## EIS 2 – Northwest rail link

Name                Brian Walters;  
Address            10 Mariam Place, Cherrybrook NSW 2126;  
Telephone        9659 0106 (H);  
Application:      SSI-5414.

Figure 6.12 Cherrybrook Station - Indicative vehicle and pedestrian movements

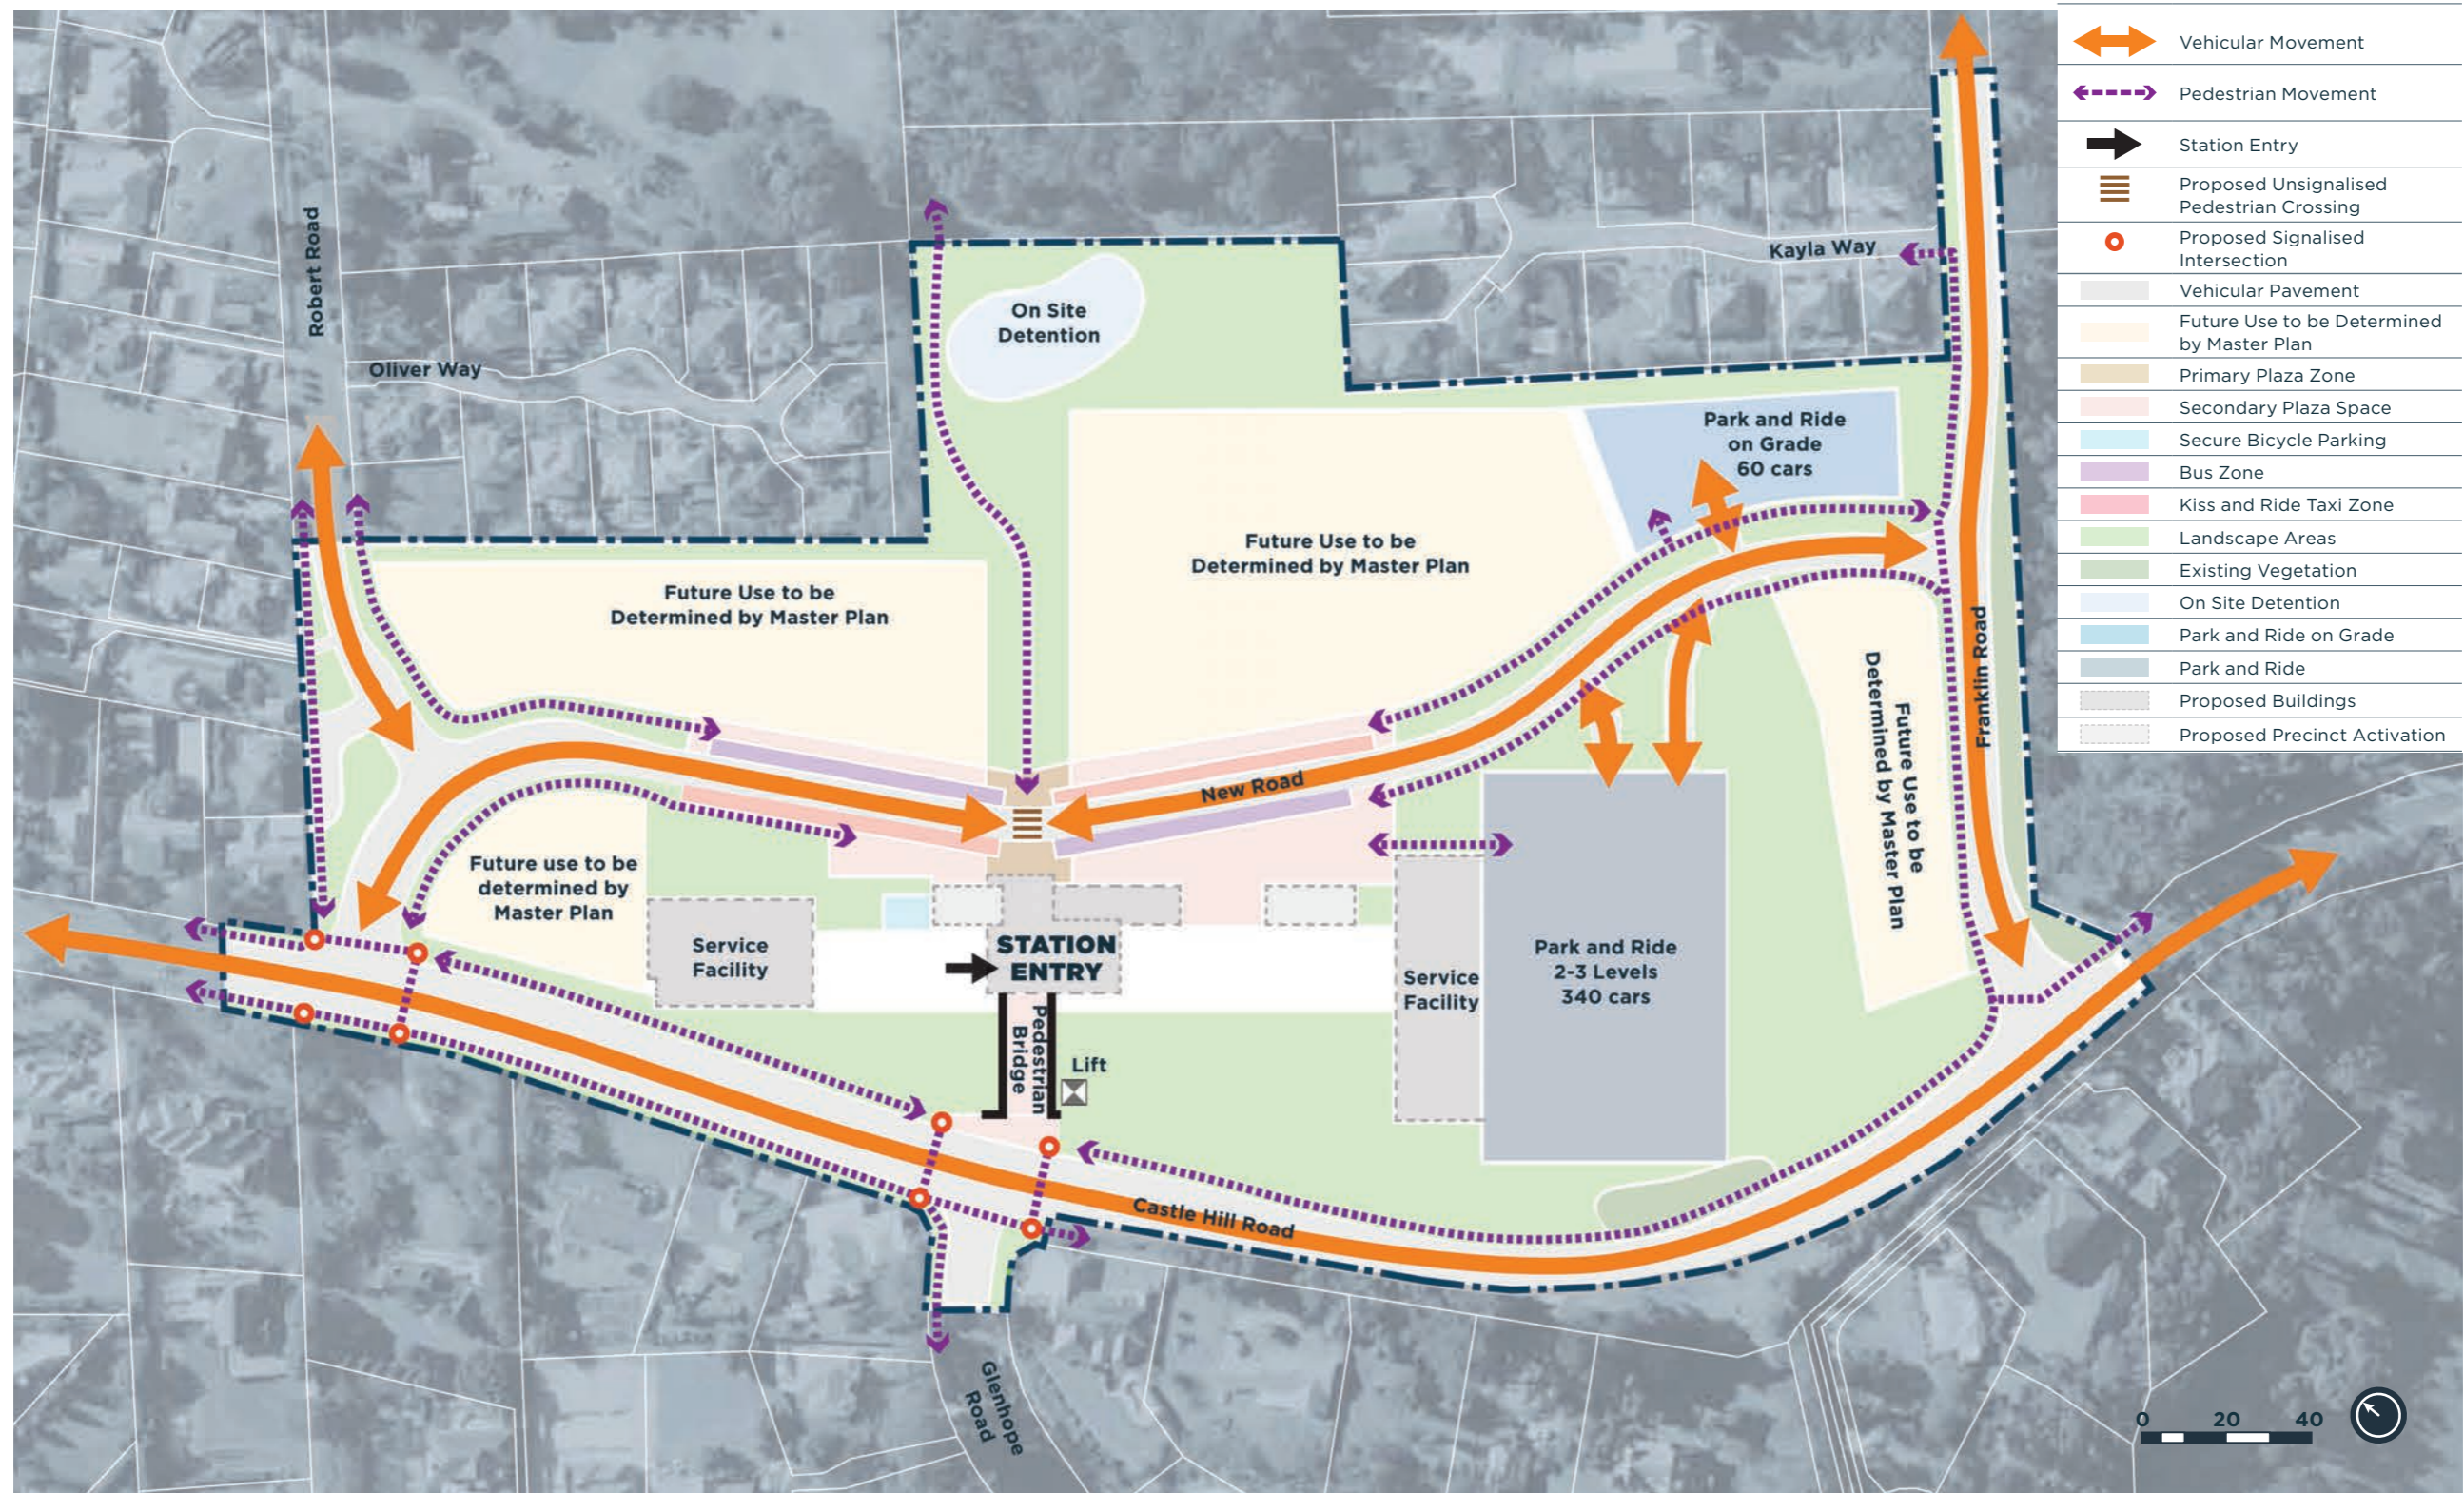
- The main concern is the amount of car parking spaces that has been proposed – 400 may not be enough based on my observations of Beecroft, Thornleigh and Cheltenham stations. There is an area adjacent to the proposed commuter parking ("Future use") that could be converted to more car spaces;

- Another concern is Roberts Road (western boundary of station) - there have been some changes to the intersection with Castle Hill Road that should stop potential "rat running" from that direction; however, there is likely to be a high volume of traffic using this road from the northerly direction which will cause problems for the existing local residents;

- Parking in local streets such as Roberts Road is also likely to be a problem – the use of time limits or no parking signs will potentially solve this problem but may push commuter parking into nearby streets as happens currently around Beecroft and Cheltenham stations.
